Application Reference: BE/40/26/DOC Site Name: Chalcroft Nurseries Chalcroft Lane Bersted PO21 5TS	Initial Issue Date: 09/07/26 Issue Date: 09/07/26 Reviewer Reference: EXT/02
---	---

Summary and Recommendation:

Condition 22: **Objection**

Condition 23: **Objection**

DRAWN A Davies
ENGINEER S Doughty
DATE May 2026
CHECKED SRD
PROJECT NO. 24123
DWG NO. 504
SCALE As Shown @ A1

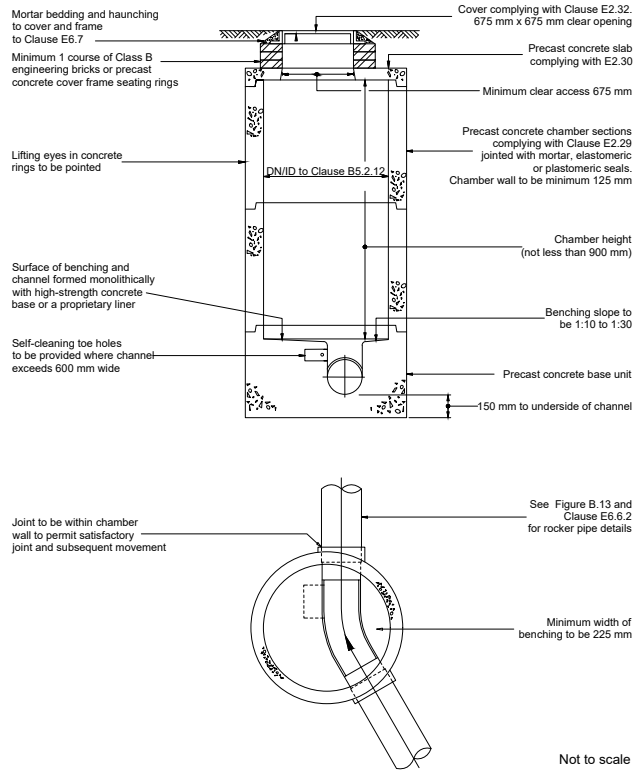
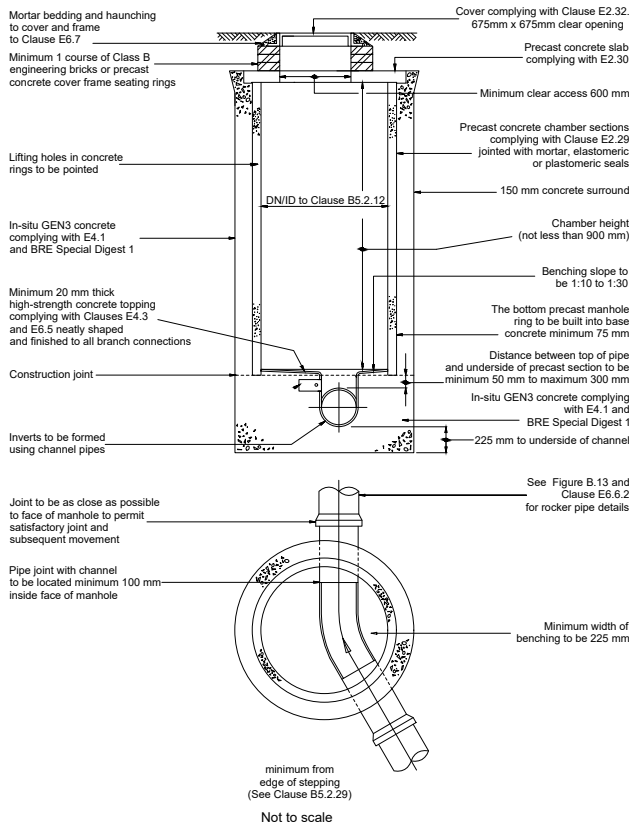
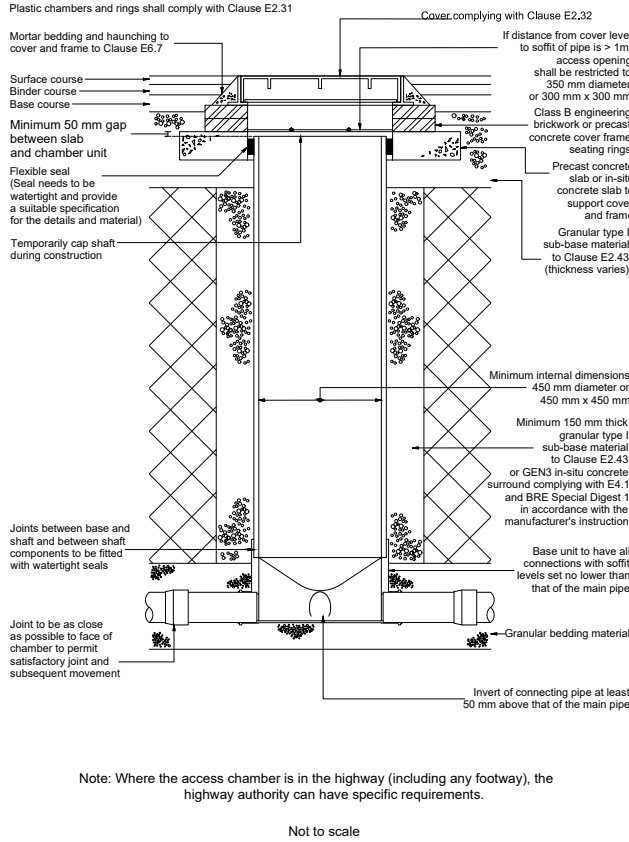
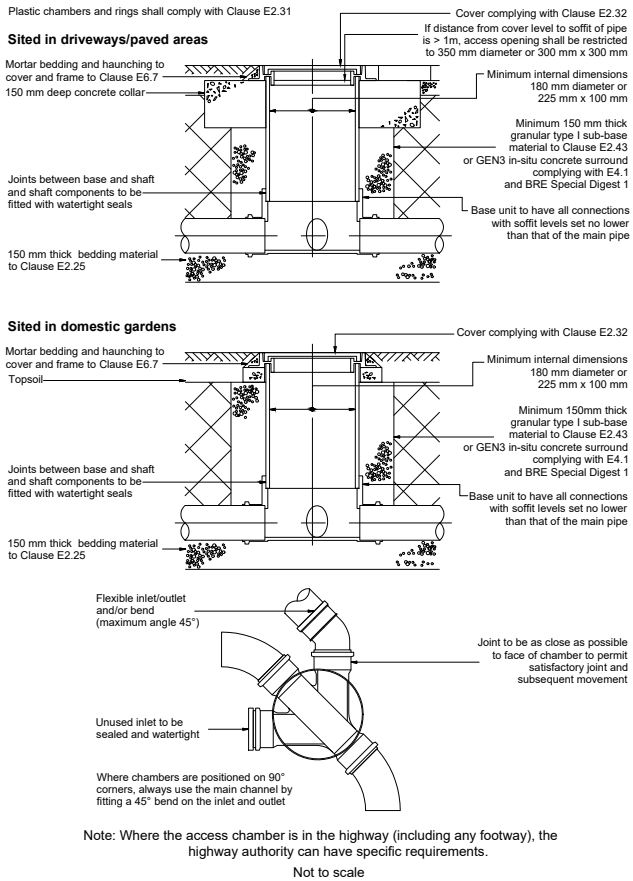
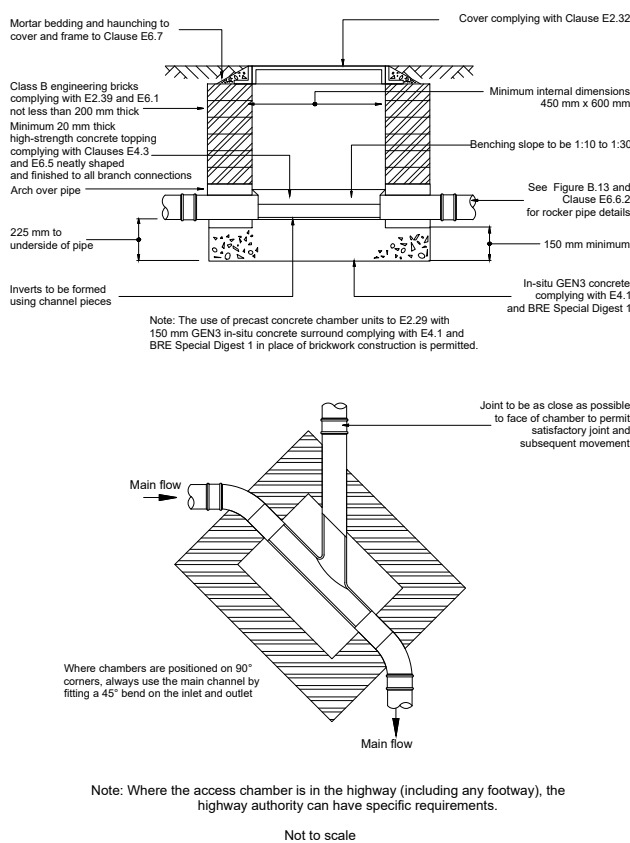
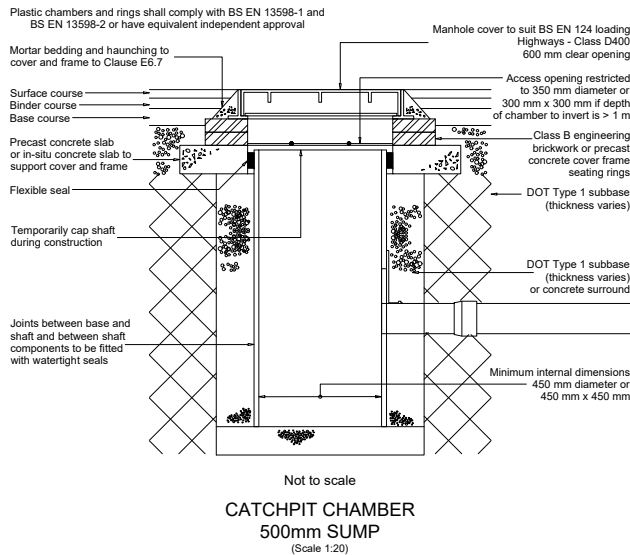
10.	Whilst some information has been provided in relation to NSfS Standard 7 relating to operation, maintenance, decommissioning and structural integrity, no	A Drainage Management and Maintenance Plan has been provided in accordance with condition 23 of the Planning Permission.

construction details have been provided for the components of the drainage system.	Drainage construction details have been provided on Drawing 501A, 502A and 504 submitted with the application.
